REFERENCE EML-OUT/20-007/20200505-165046-945

I would appreciate confirmation within the next 10 days, that the proposed kitchen extension will not include additional and/or altered extraction/ventilation/air conditioning as a result of the proposal.

Kitchen Extension Proposed
1 : 50

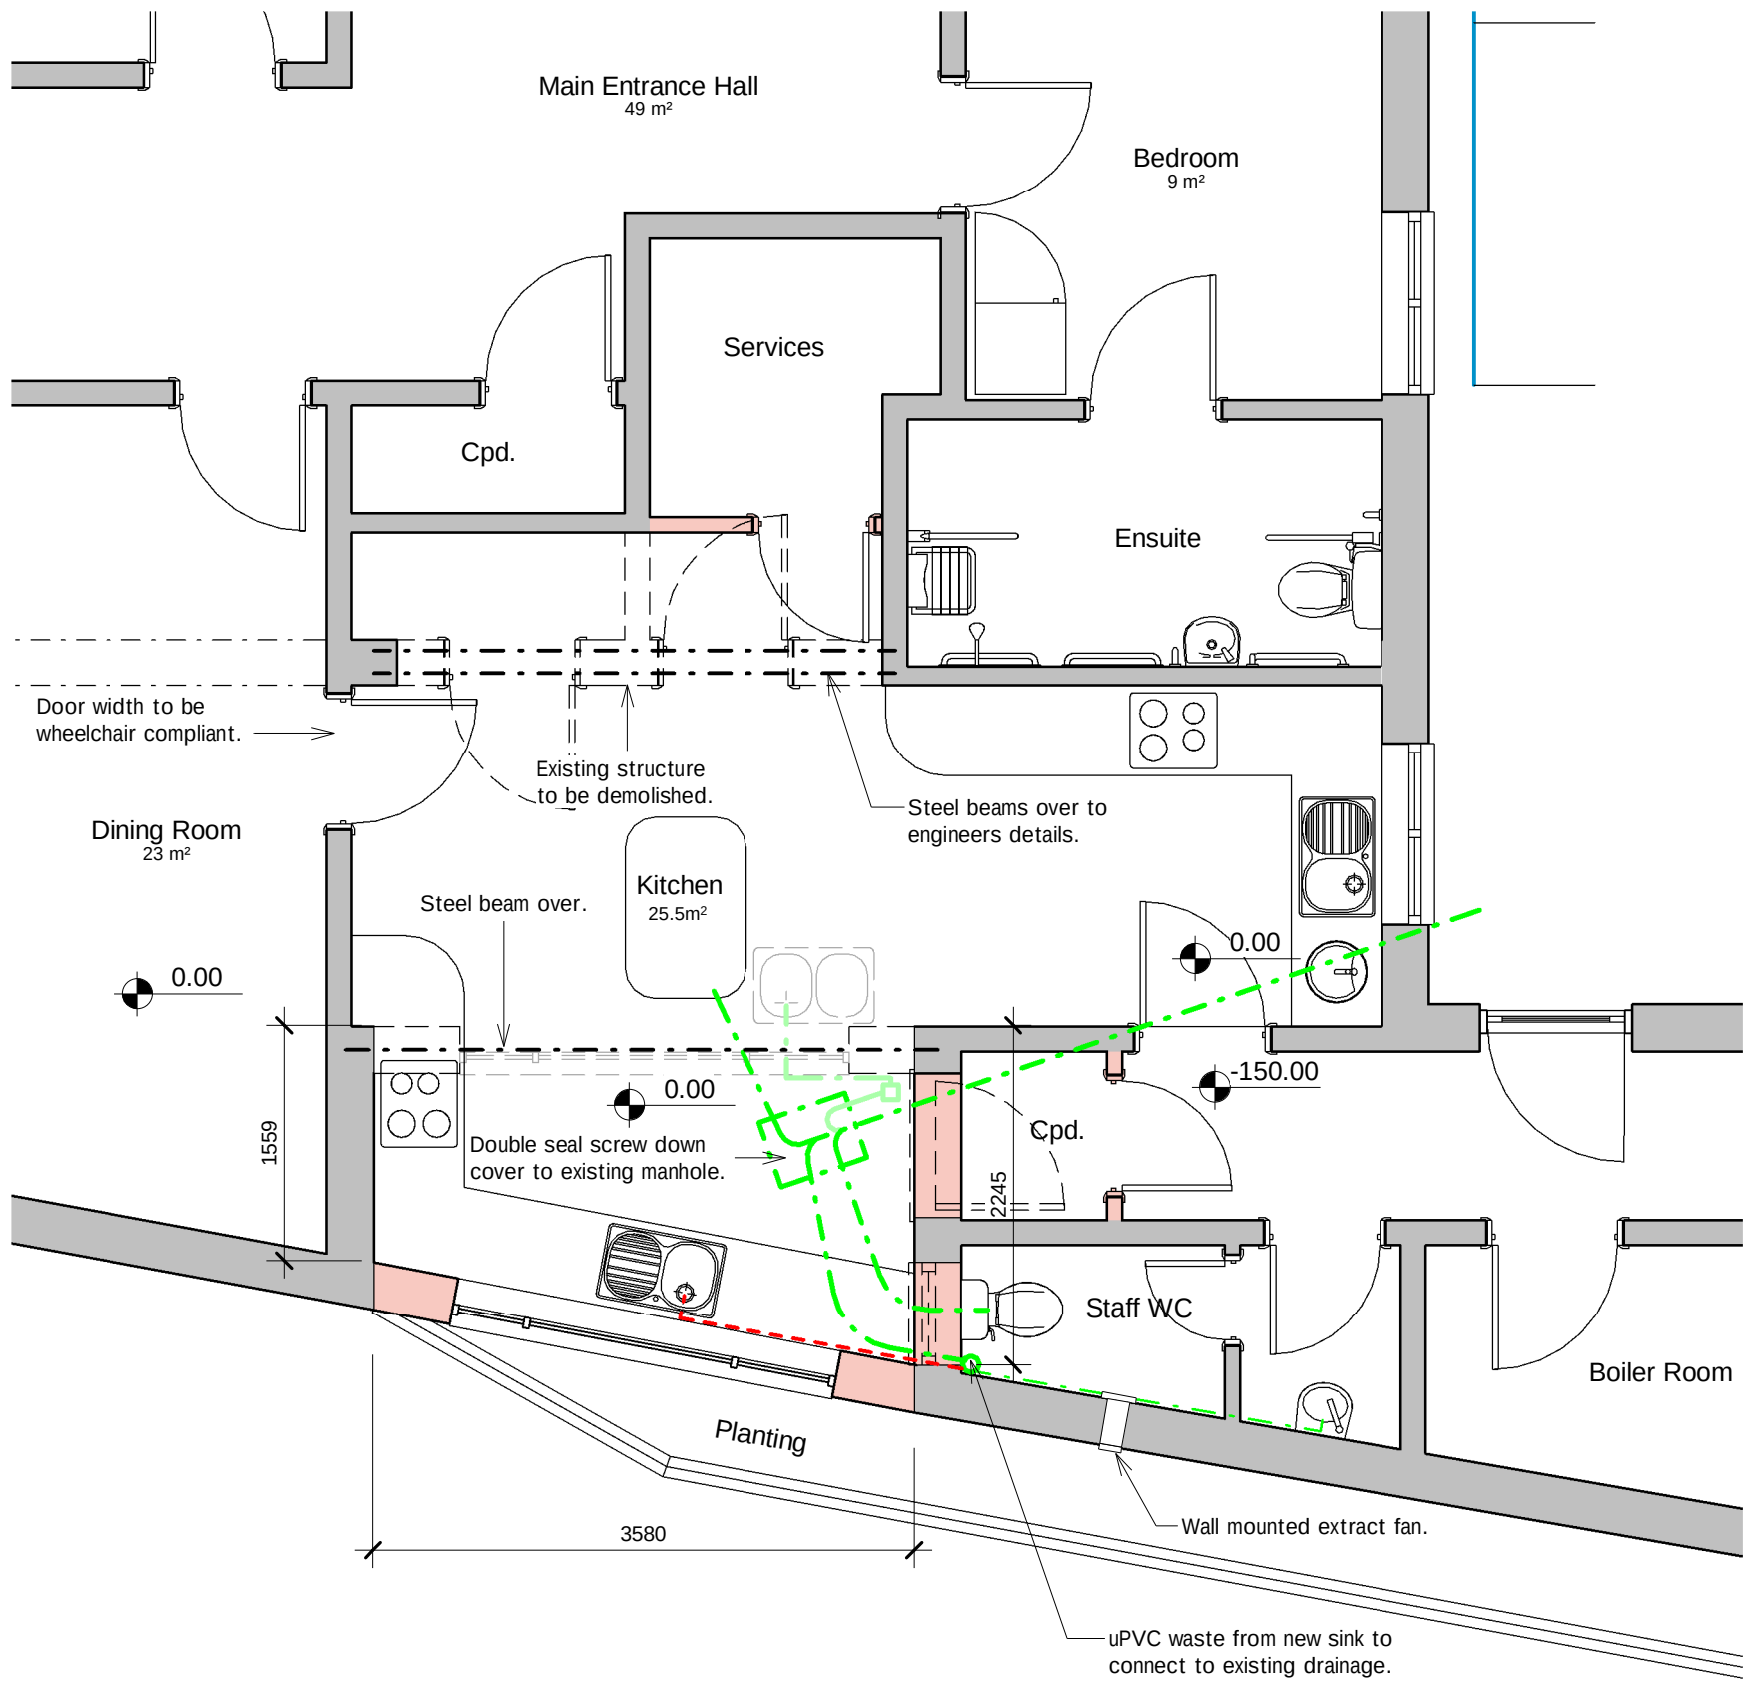
In relation to the above application, I note that section 20 of the application form has been completed 'N/A'; could the applicant please confirm whether this means that the proposed kitchen extension will not include additional and/or altered extraction/ventilation/air conditioning equipment?

In response to your query, the existing cooker and extraction is to remain and if an additional cooker is required by the client there will be a domestic type extract/cooker hood installed to the following specification.

'Kitchen to have mechanical ventilation with an extract rating of 60l/sec or 30l/sec if adjacent to hob to external air, sealed to prevent entry of moisture. Intermittent extract fans to BS EN 13141-4. Cooker hoods to BS EN 13141-3. All fixed mechanical ventilation systems, where they can be tested and adjusted, shall be commissioned and a commissioning notice given to the Building Control Body.'

Please note that this is not a commercial scale kitchen, it is used solely to provide food for the small number of residents.'
